Subject: NSW PLANNING & ENVIRONMENT DEVELOPMENT APPLICATION SSD 7500 RE 5 and 9 Culverston Road, Minto

I refer to NSW Planning & Environment's letter of 14 June 2016 regarding Development Application SSD 7500 at 5 and 9 Culverston Road, Minto (Lot 3 in DP 817793 and Lot 400 in DP 875711) for 'Warehouse and Logistics Hub'. Submissions need to be made by 1 August 2016.

Site Plan from Endeavour Energy's G/Net Master Facility Model

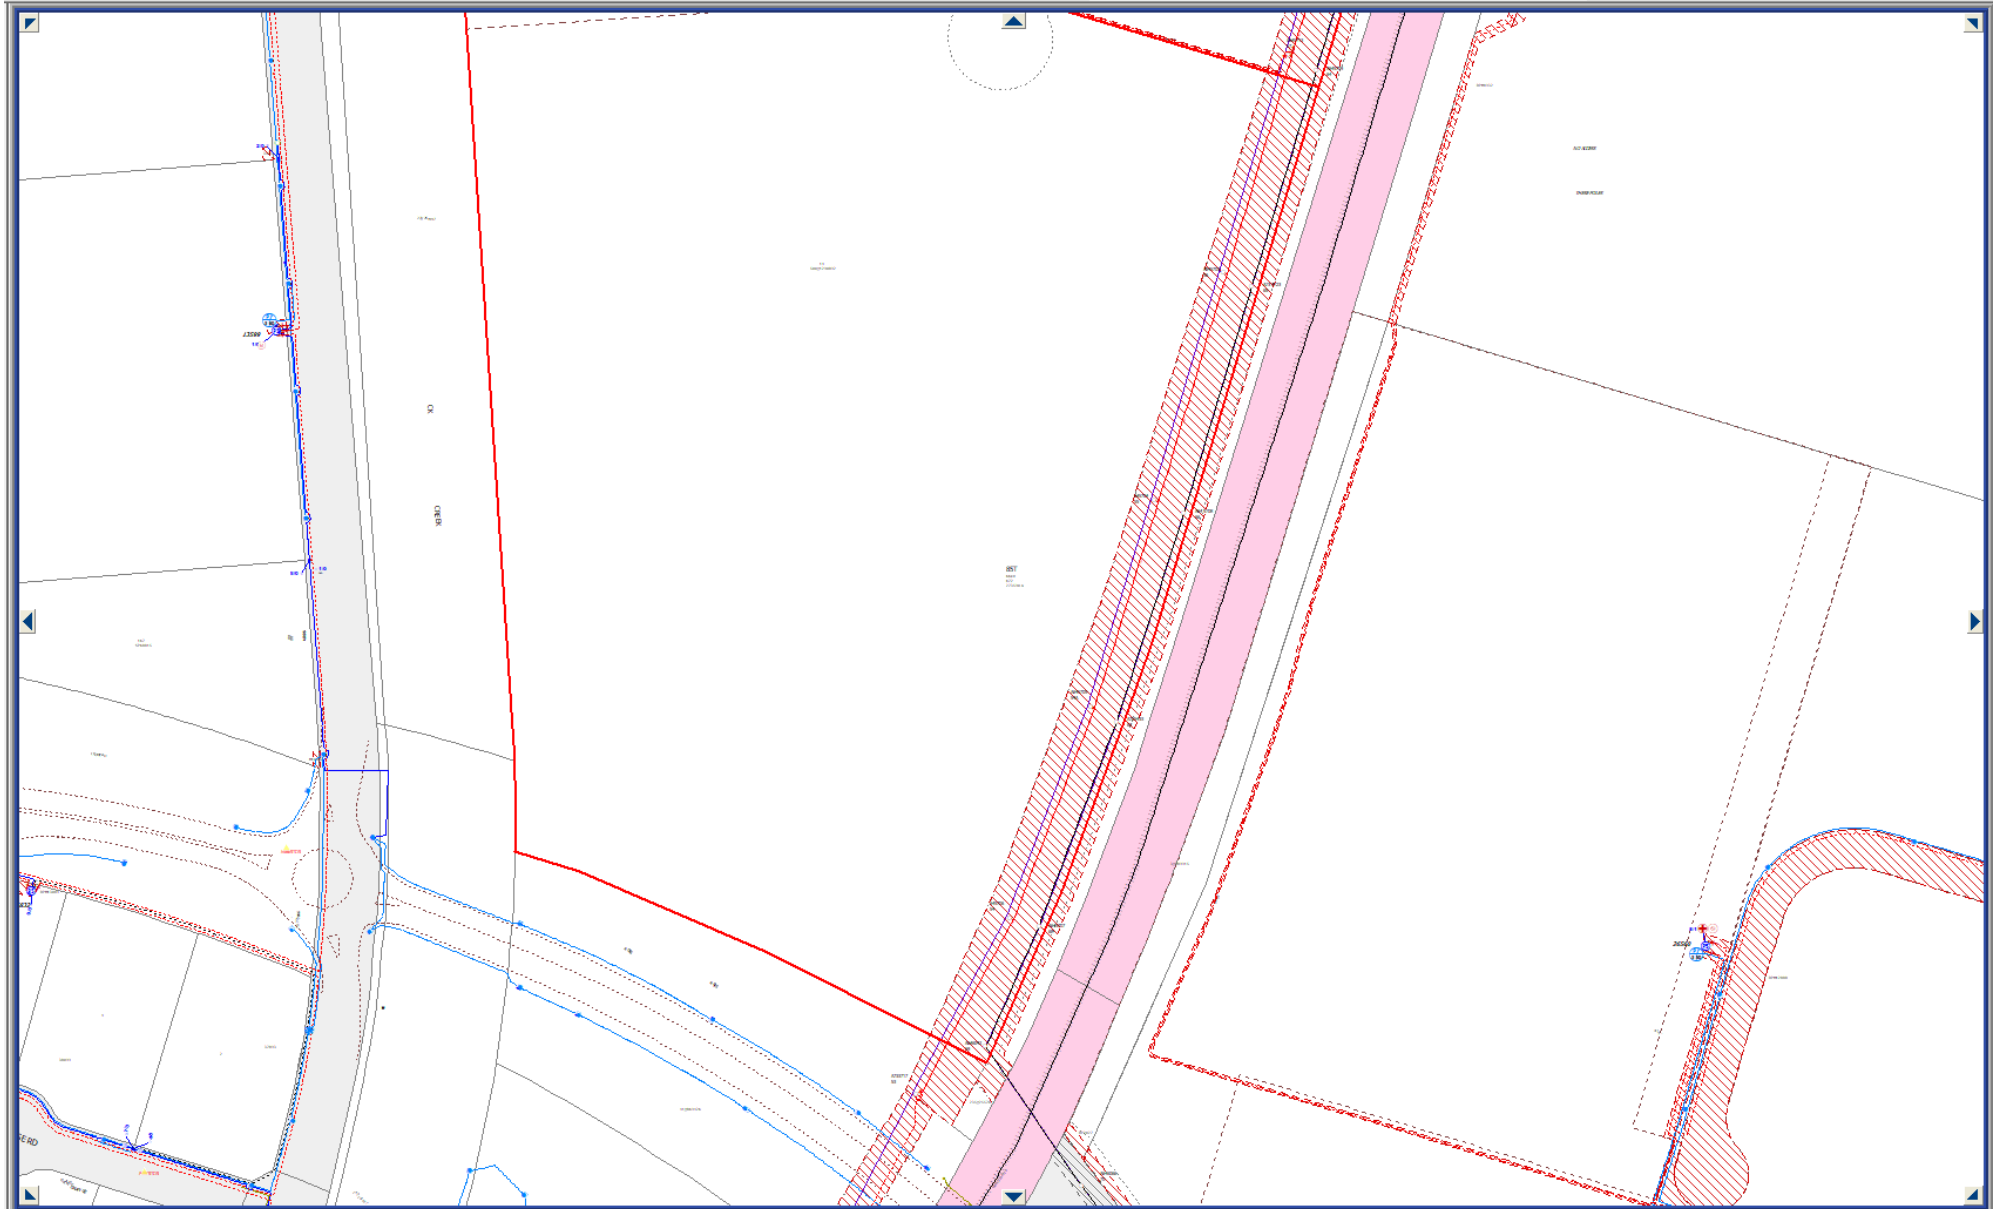
In regards to the final paragraph, as shown in the below site plan from Endeavour Energy's G/Net master facility model for Lot 400 in DP 875711, it would appear that the 'asset heading east from the kiosk substation' appears to have been intended to facilitate a proposed subdivision of the lot.
